Recommendation Report for Planning Permission for Works or Extension to a Dwelling

REF NO: WA/41/18/HH

LOCATION: Ashgrove
West Walberton Lane
Walberton
BN18 0QS

PROPOSAL: Orangery to side elevation.

PROPOSED ELEVATIONS

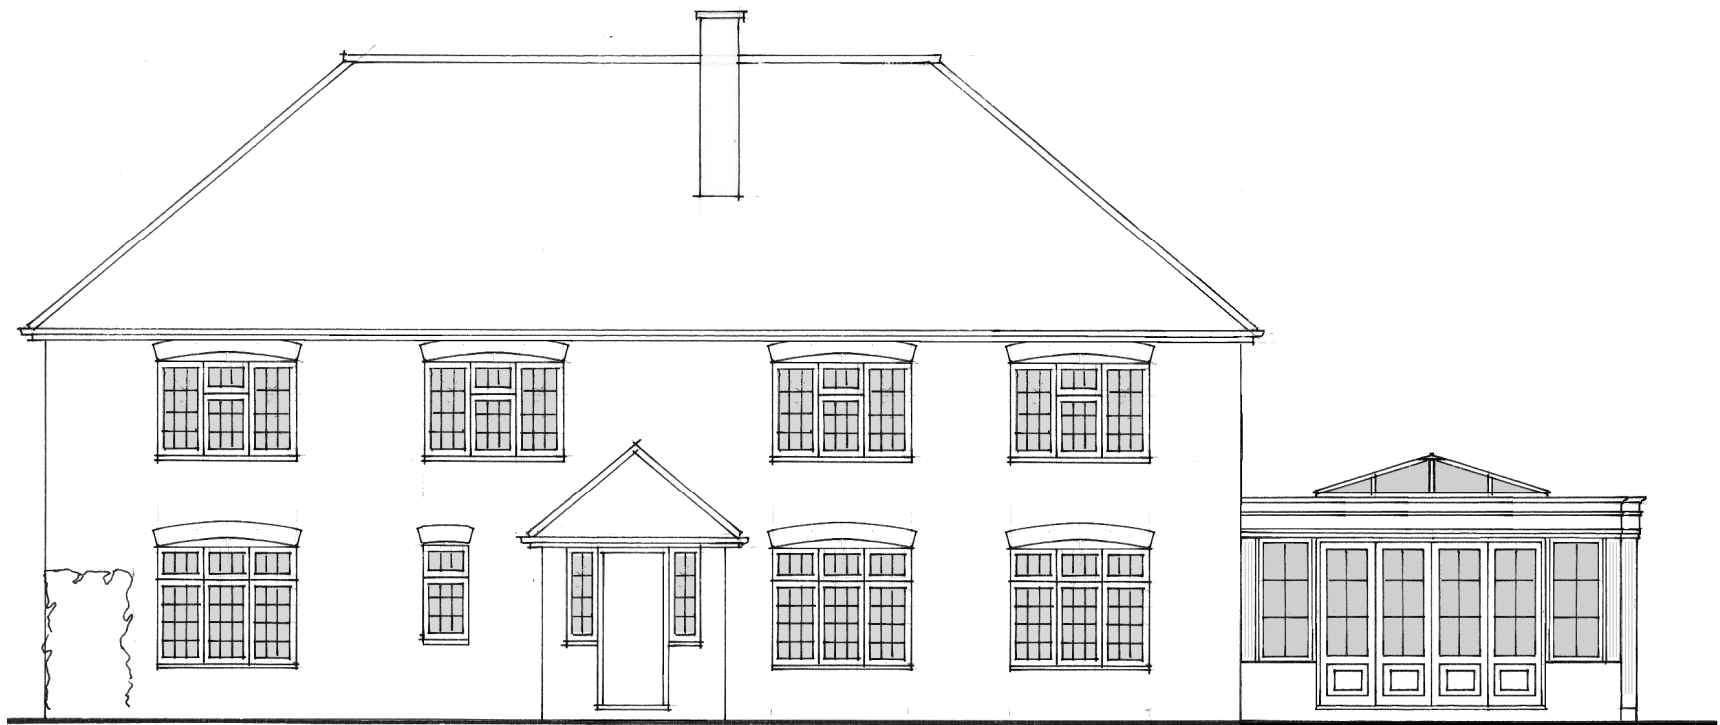
DESCRIPTION OF APPLICATION As above. The orangery would have a floor area of 5.2m by 9m and an overall height of 3.5m, with an eaves height of 3m. It would be constructed of hardwood with brickwork to match the existing dwelling.

Given the limited scale of the proposed extension it would appear subservient to the host dwelling. It is not considered to have a significantly detrimental impact on the established character of the host dwelling as a result of its design and use of materials. It would appear visually integrated well with the existing dwelling. Therefore, the proposed extension is considered to be in compliance with DEV19(i) and (ii) of the Arun District Council Local Plan.

The extension would be located forward of the side elevation of the existing dwelling. However it would not be readily visible from the street scene, given its height, set back position and the presence of the

existing mature hedging around the site. The area is characterised by detached dwellings of varying design in large plots with space to site boundaries. The position and dimensions of the extension would be in keeping with the appearance of the dwelling and the area generally. The proposal would not erode this established character. The extension would be located a minimum of 17m from the site boundaries and 37m from the site frontage. The development is not considered to be visually harmful to the established character of the area or the property. The area does not have a uniform spatial character. As a result of this, the proposal is deemed to be in accordance with HP1 & HP13 of the Walberton Neighbourhood Development Plan and GEN7(ii), DEV19(iv) and (v) of the Arun District Council Local Plan.

PROPOSED FLOOR PLAN

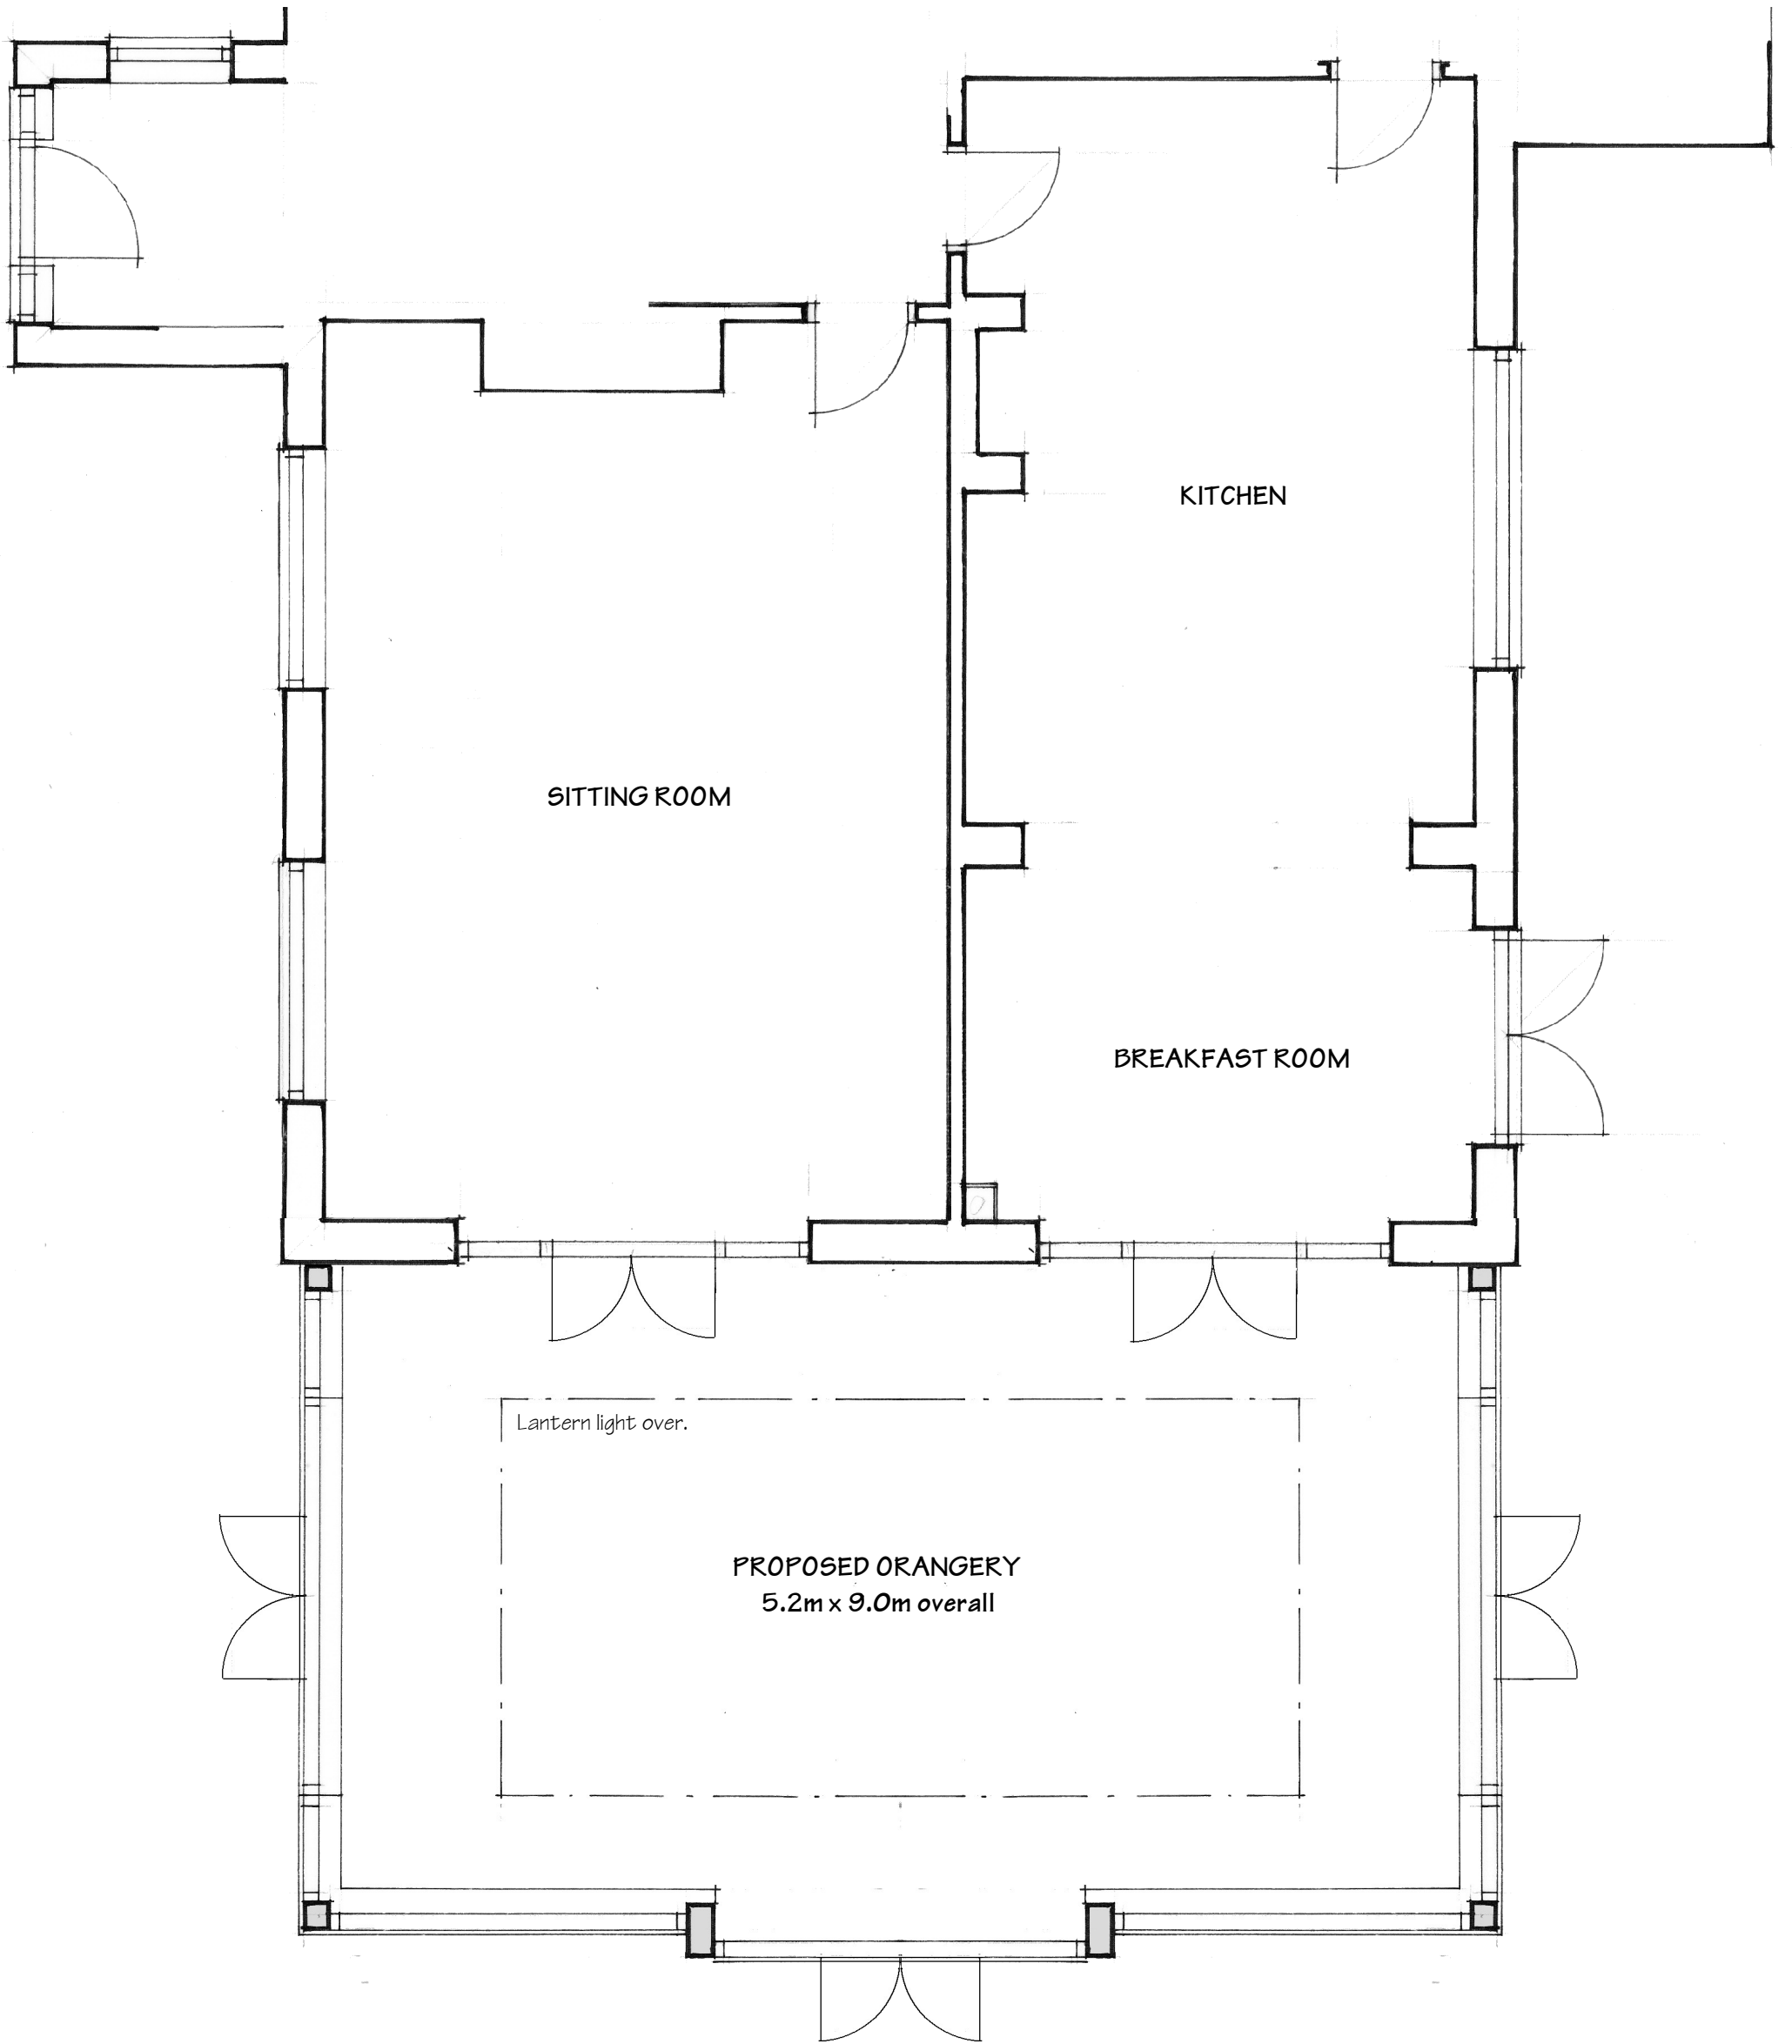
The proposed extension is not considered to give rise to any significantly adverse impact on the neighbouring dwellings given the single storey nature of the development and the distance to site boundaries. As such, the proposed development is considered to be in accordance with GEN7(iv) and DEV19(iii) of the Arun District Council Local Plan.
